BCA ASSESSMENT REPORT

**Oakdale West Estate, Kemps Creek
Building 2C & 2D**

**Prepared For:
Goodman Property Services (Aust) Pty Ltd**

Date: 15 October 2021

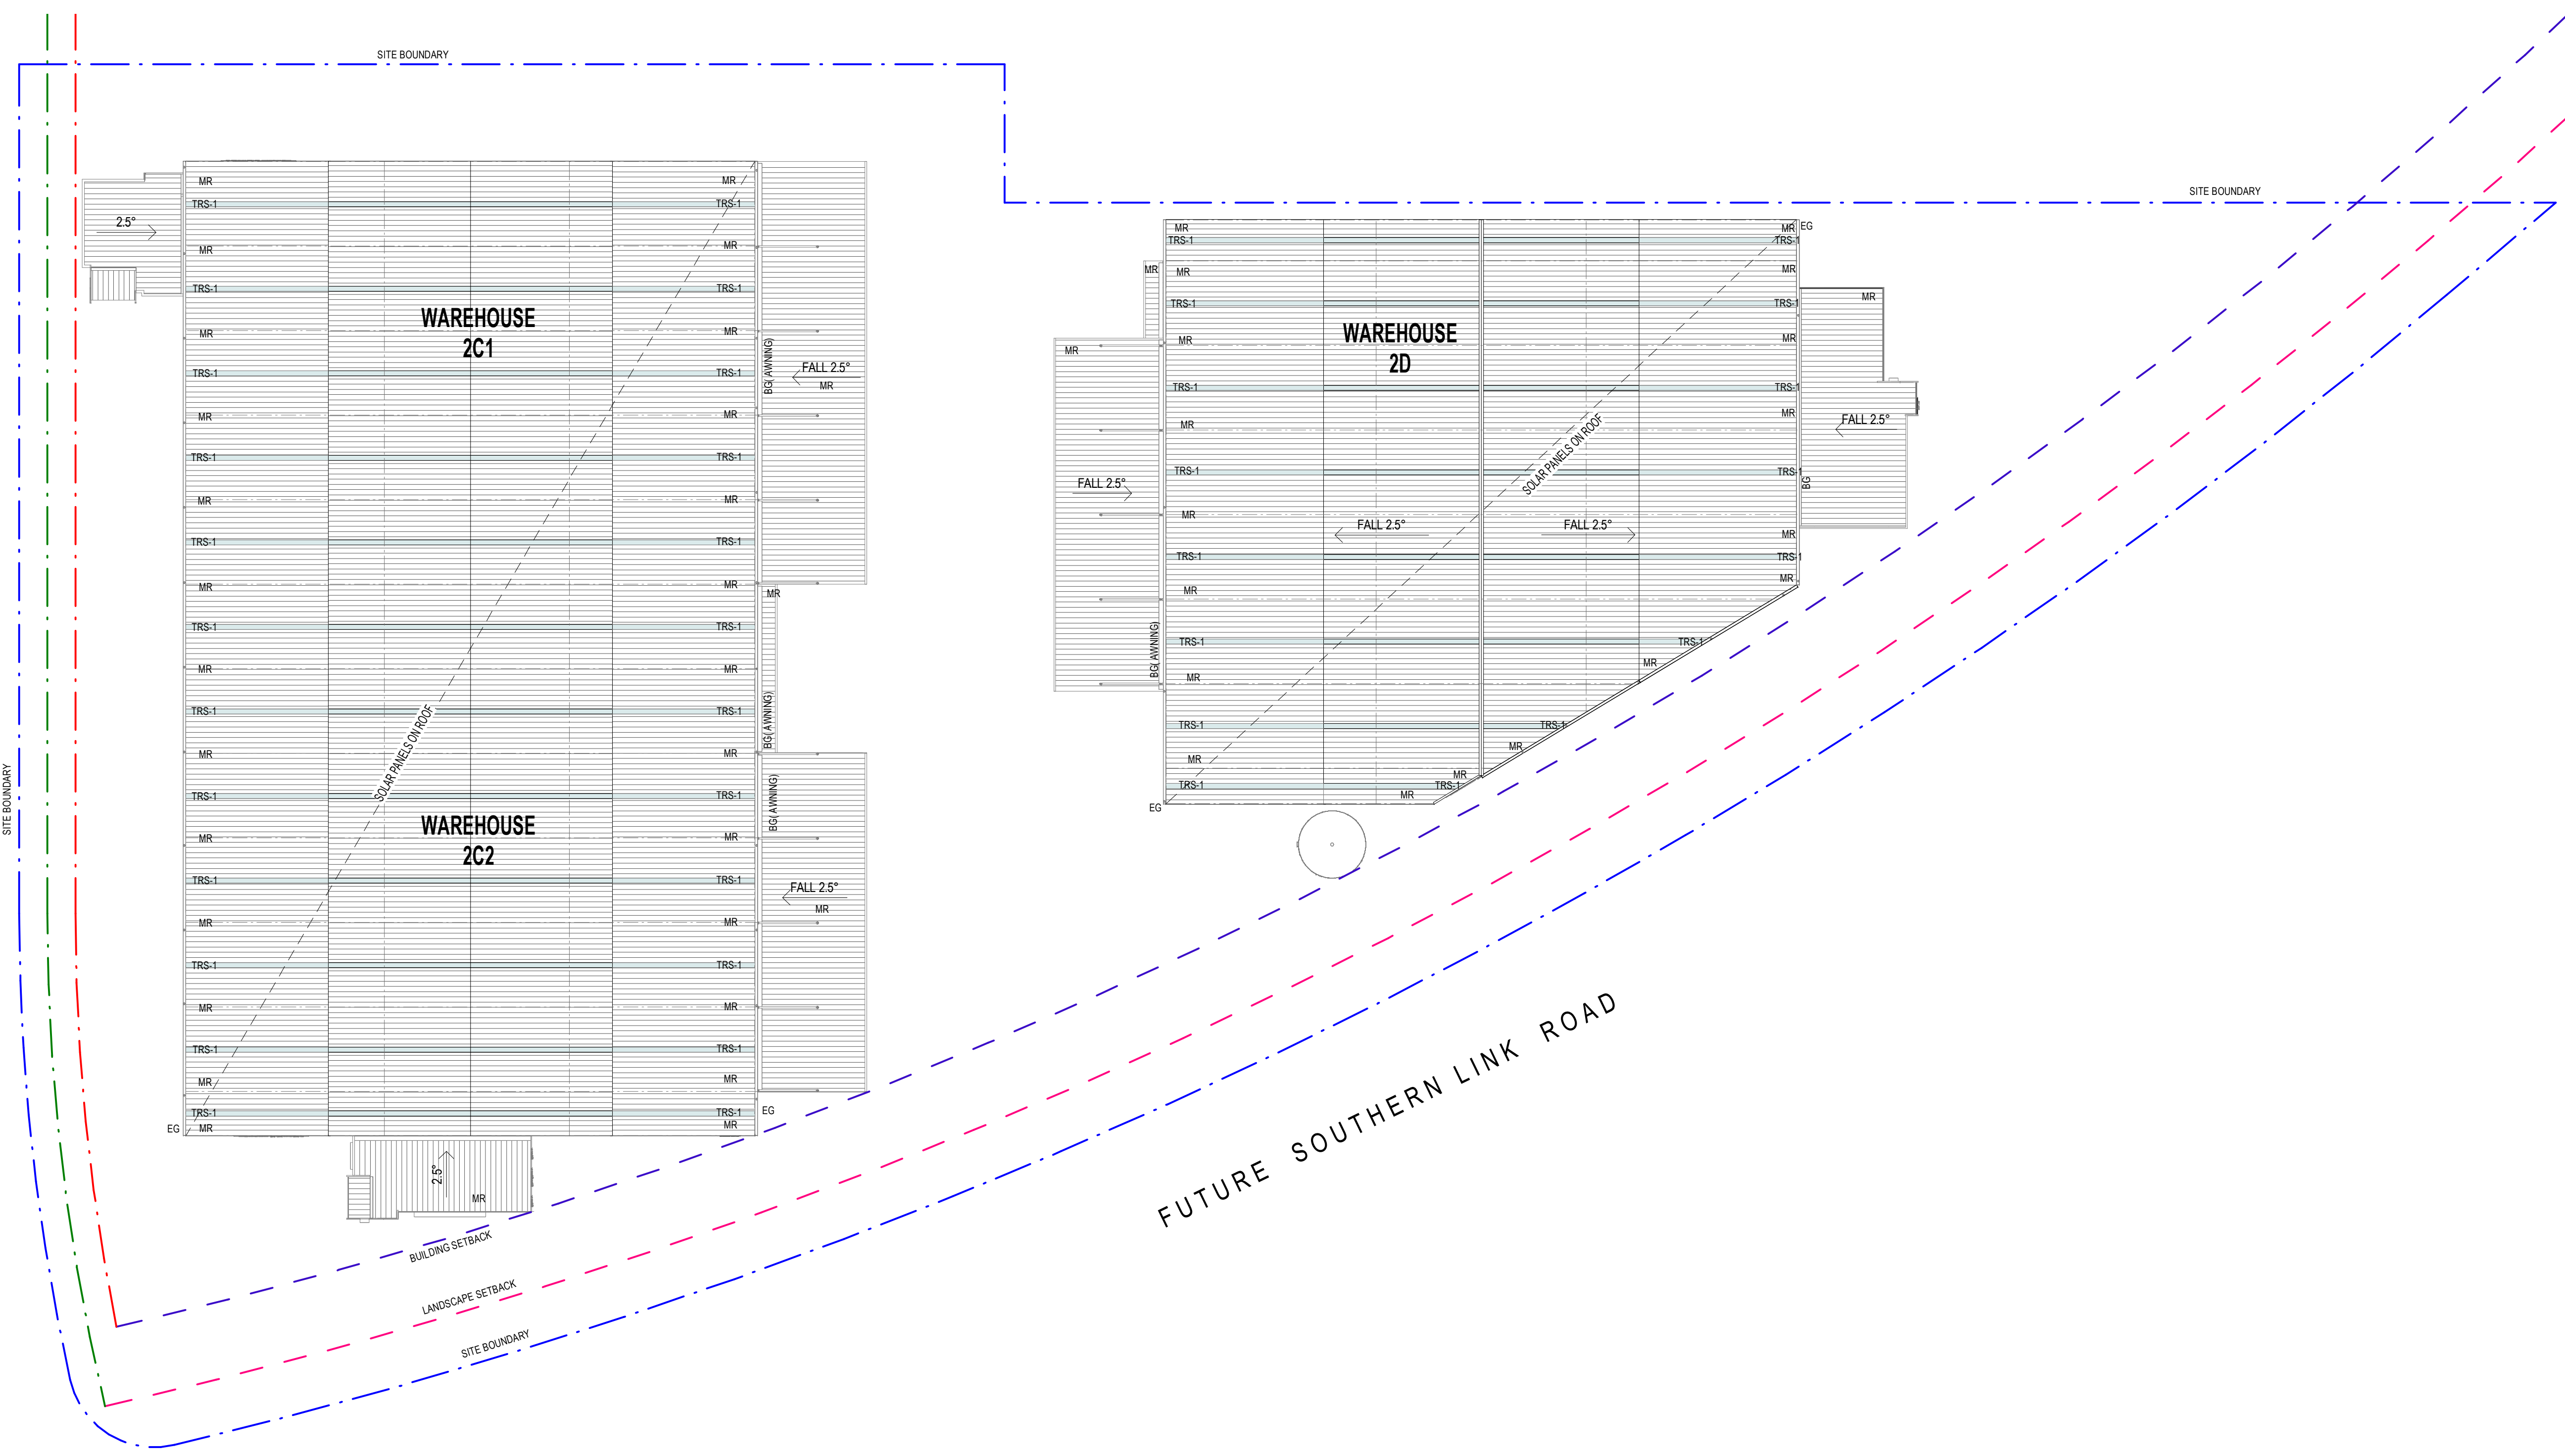
Comments: The proposed buildings do not comply with the provisions of C2.4 and thus the following non-compliance areas are identified on the site plan (over page) that are required to be addressed as an Performance Solution by the Fire Safety Engineer for each building, as follows:

- *Perimeter Vehicular Access is greater than 18m from the external walls of Building 2C & 2D as shown in red below.*
- *Perimeter Vehicular Access is not provided to northern external wall of Building 2D (three-sided access only).*

Note 1: The driveways providing vehicular perimeter access must be designed with adequate loading capacities to withstand a fire truck and the gradients of the ramps should take into consideration to the FRNSW Policy 4 Vehicular Access Guideline.

Note 2: If the perimeter access paths are reduced to less than 6m in width to accommodate pedestrian egress paths per Clause D1.10 below, this will need to be documented in the Performance Solution.
